From: nwdonnelly <nwdonnelly@btinternet.com>
Sent: 24 March 2021 11:23
To: Planning
Cc: chippingparishcouncil@outlook.com; Cllr S Hore
Subject: FAO ADAM BIRKETT: RE PLANNING APPLICATION 3/2020/1037

Re: Planning Application 20/1037

Address: Seed Hill (Land to the rear of Grove Square) Malt Kiln Brow, Chipping PR3 2GP

Description: Proposed single storey building to be used as a holiday lodge and creation of new vehicular access off Malt Kiln Brow.

CLIENT: LIFESPACE CABINS				
PROJECT: SEED HILL CHIPPING PRESTON				
DRAWING TITLE: PRELIMINARY ACCESS PROPOSALS - SITE SECTIONS				
DATE CREATED: JULY 2020	DRAWING SCALE: 1-100	DRAWN BY: MWJ	CHECKED BY: -	QA CATEGORY: 1
DRAWING REF: TC / T19581 / 20 / 101				REV: A

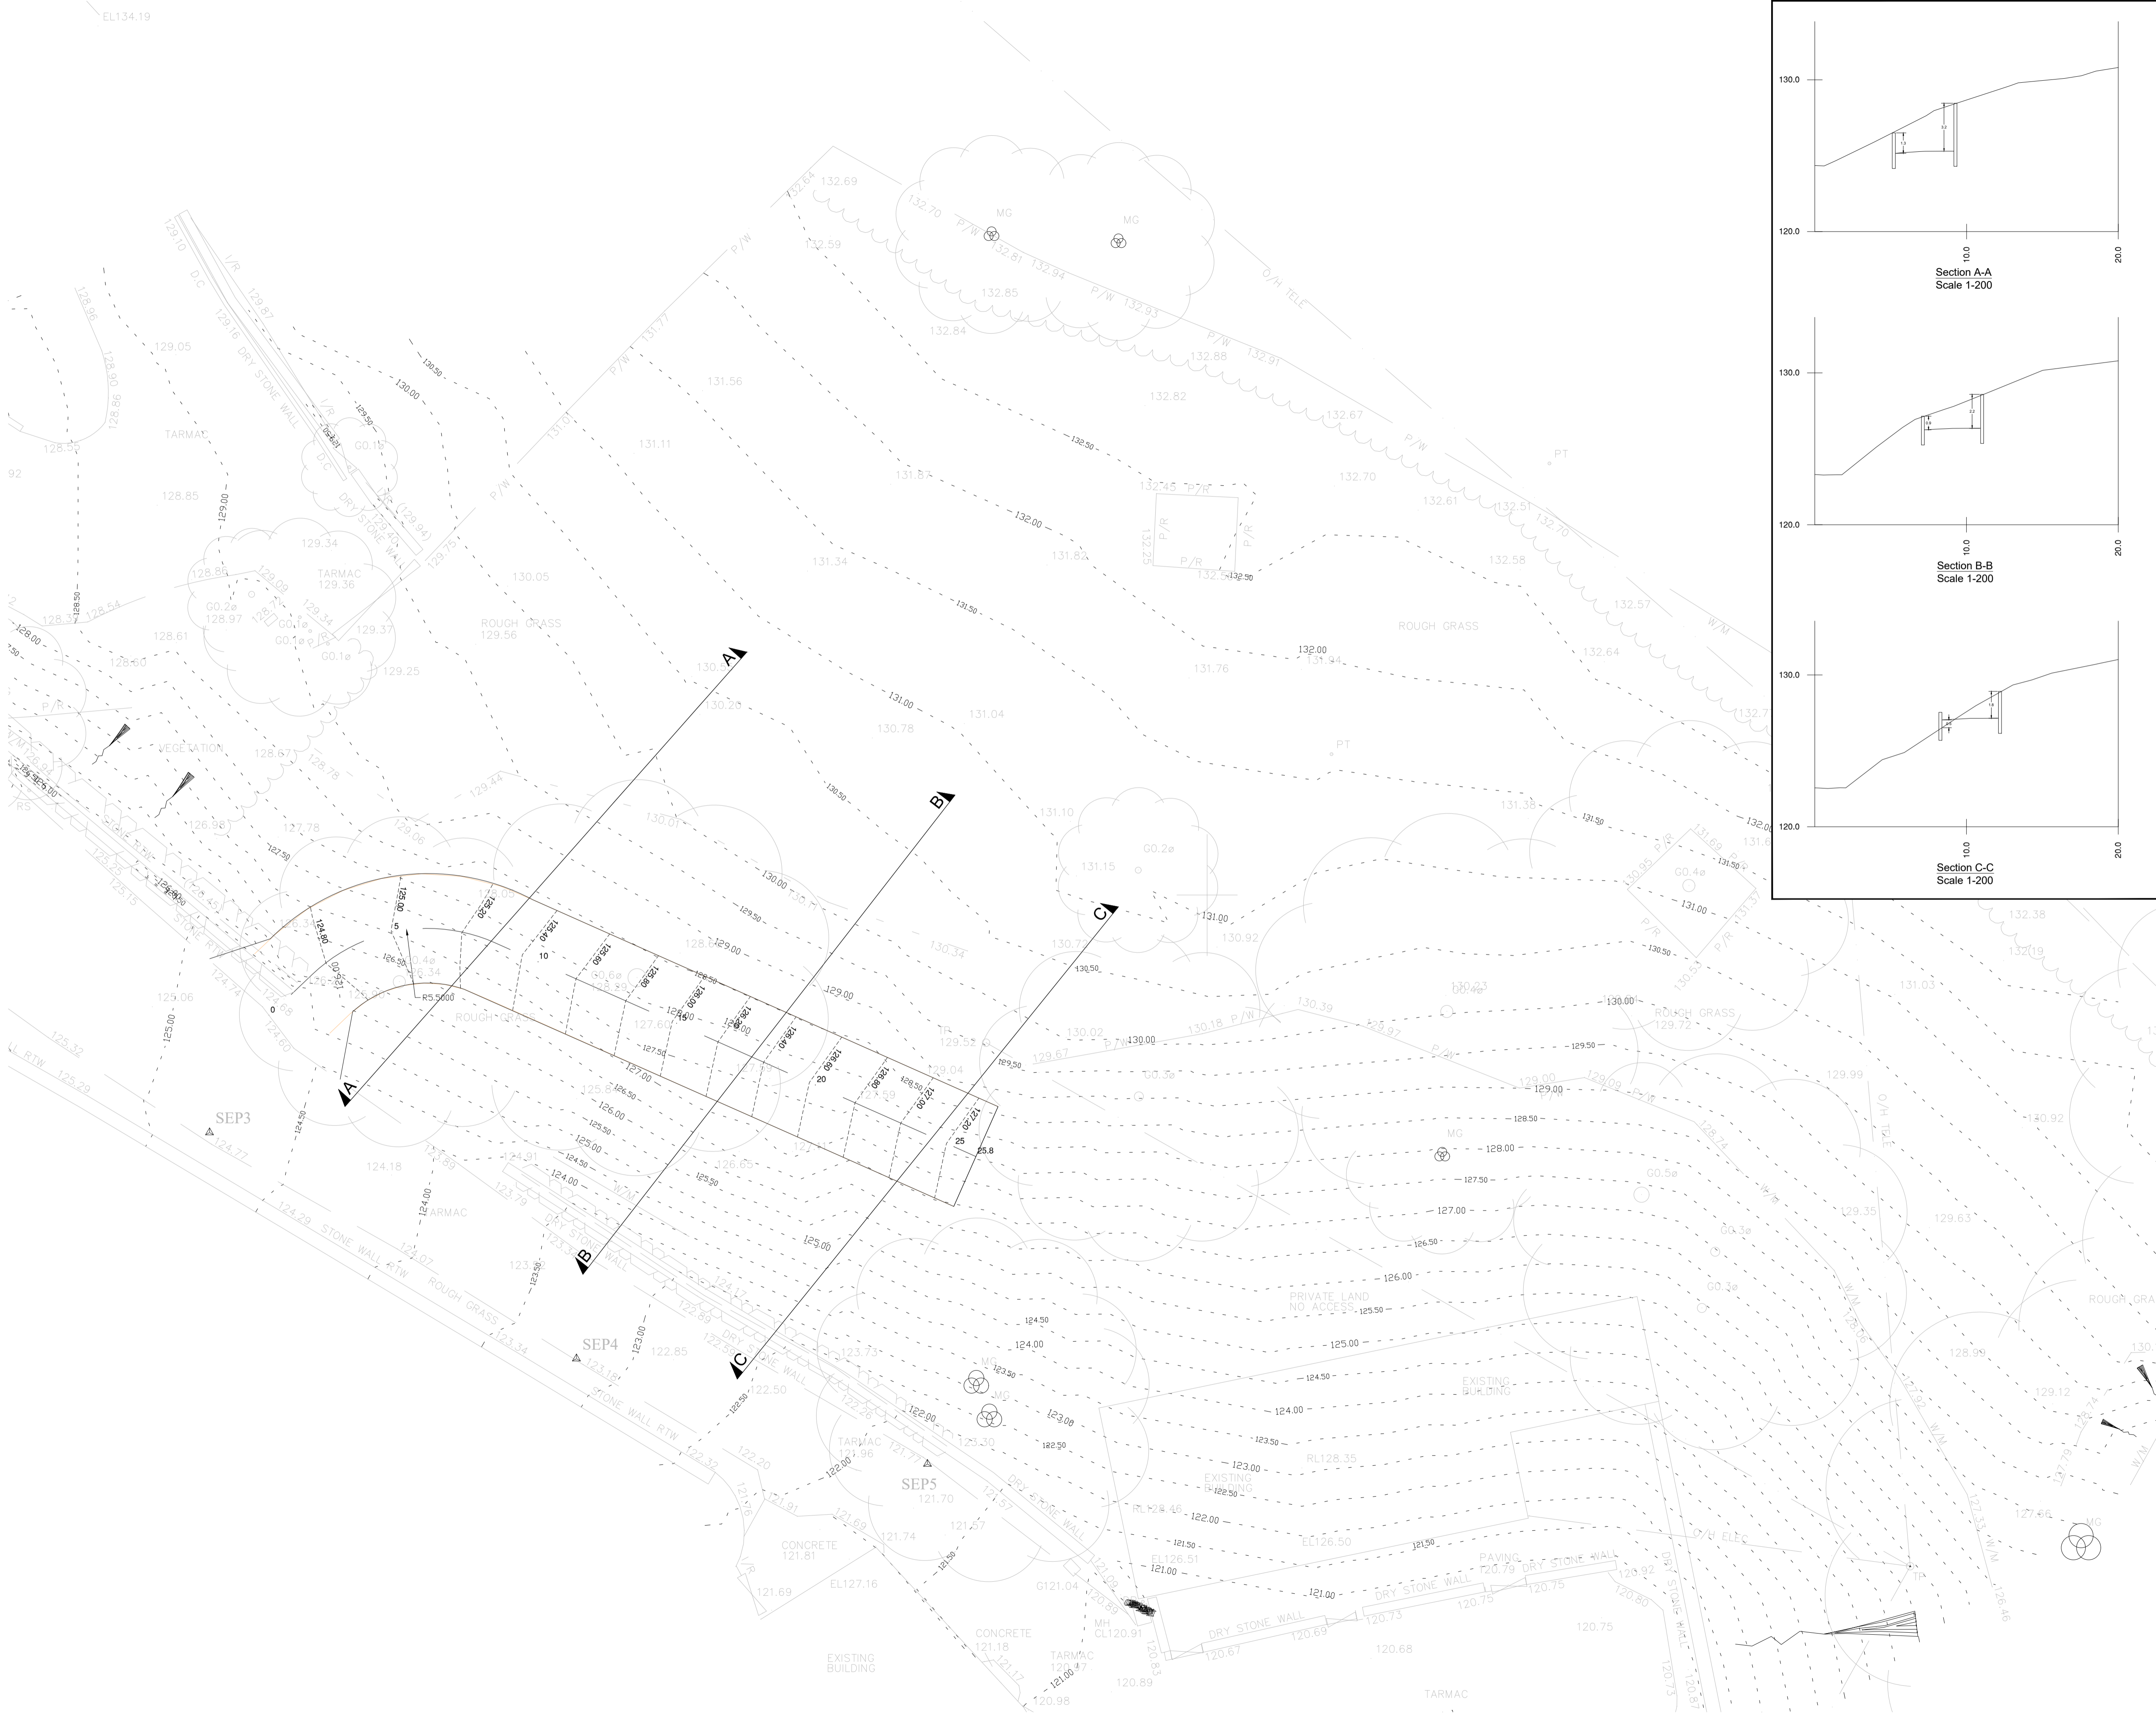
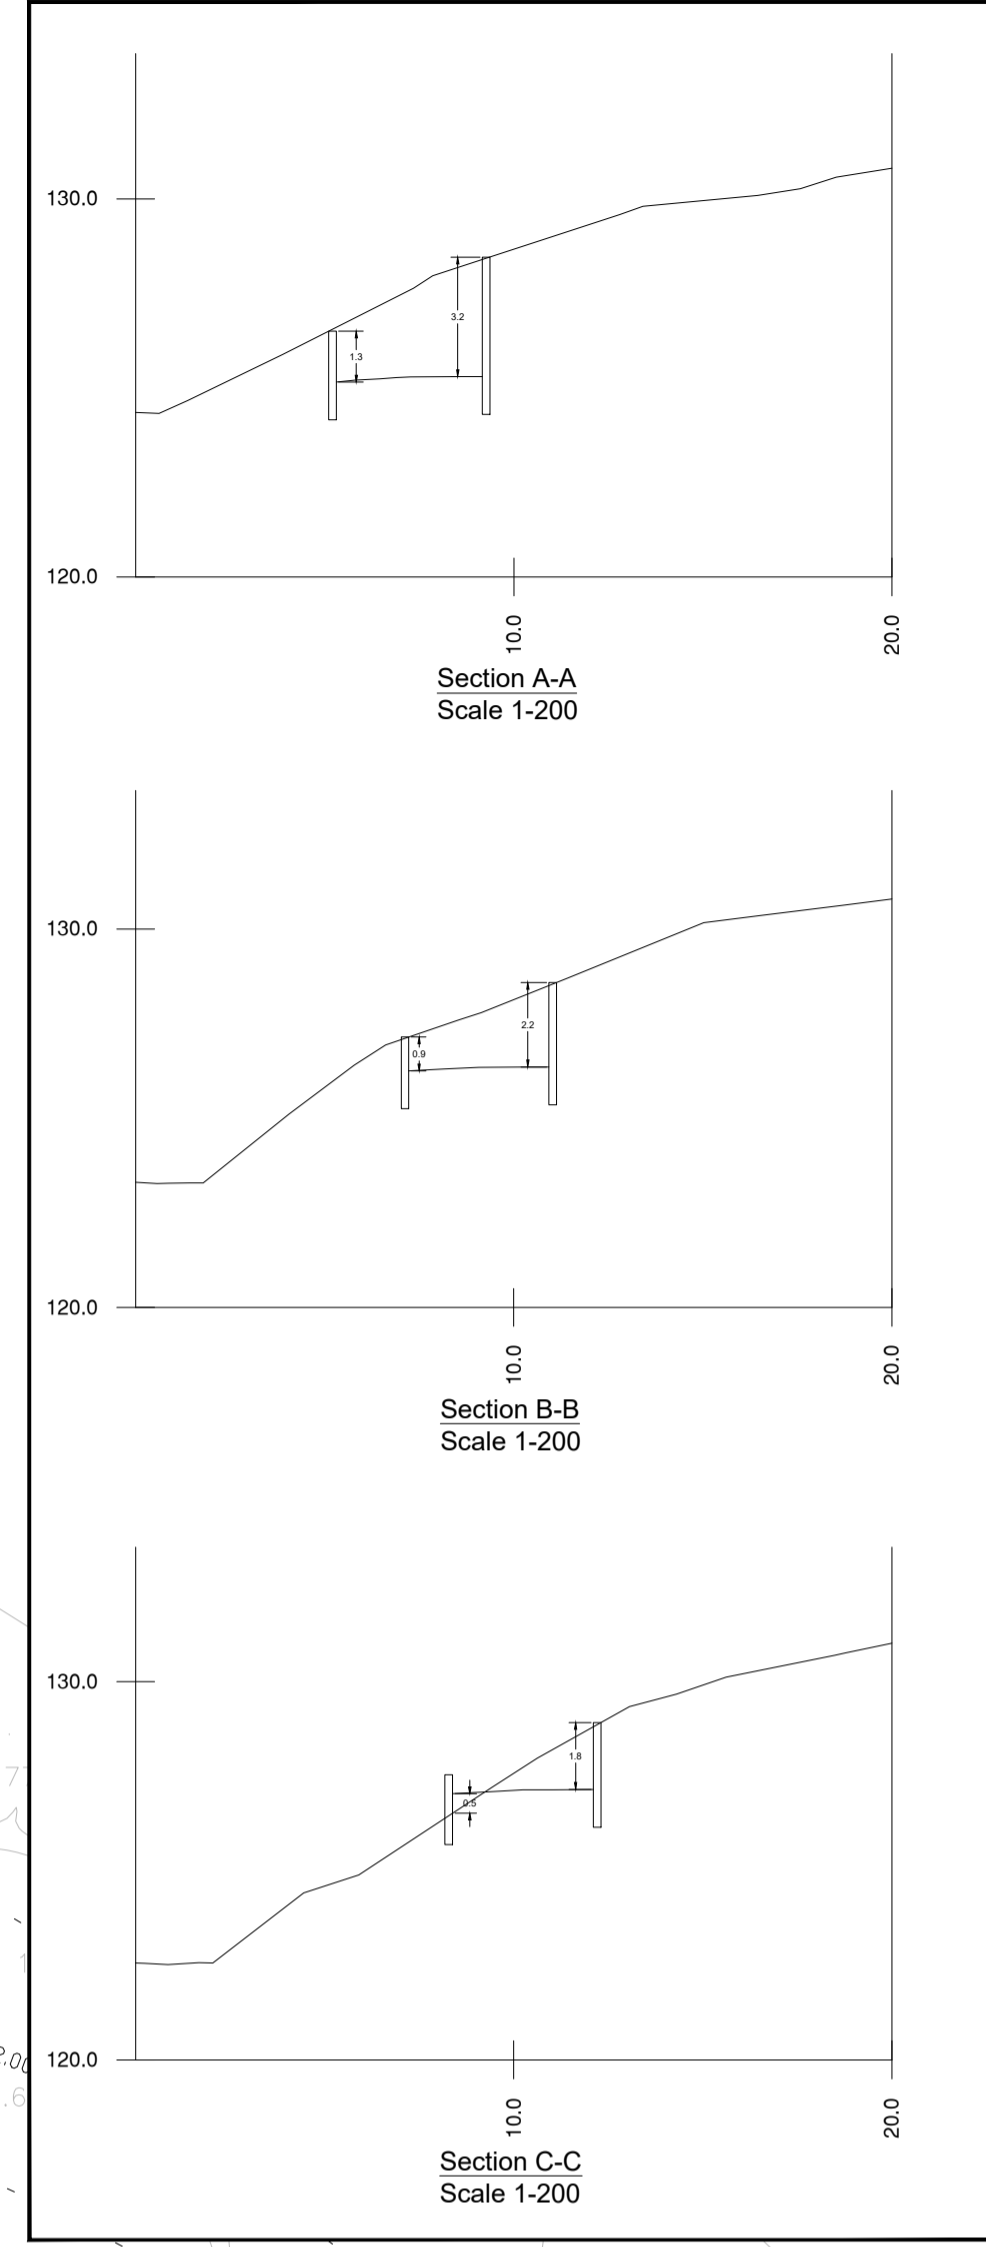
2. We have serious concerns with regard to the proposed vehicular access onto Malt Kiln Brow and we completely endorse all the points noted in the response from Mr Phil Durnell, Director Highways and Transport, Lancashire County Council.
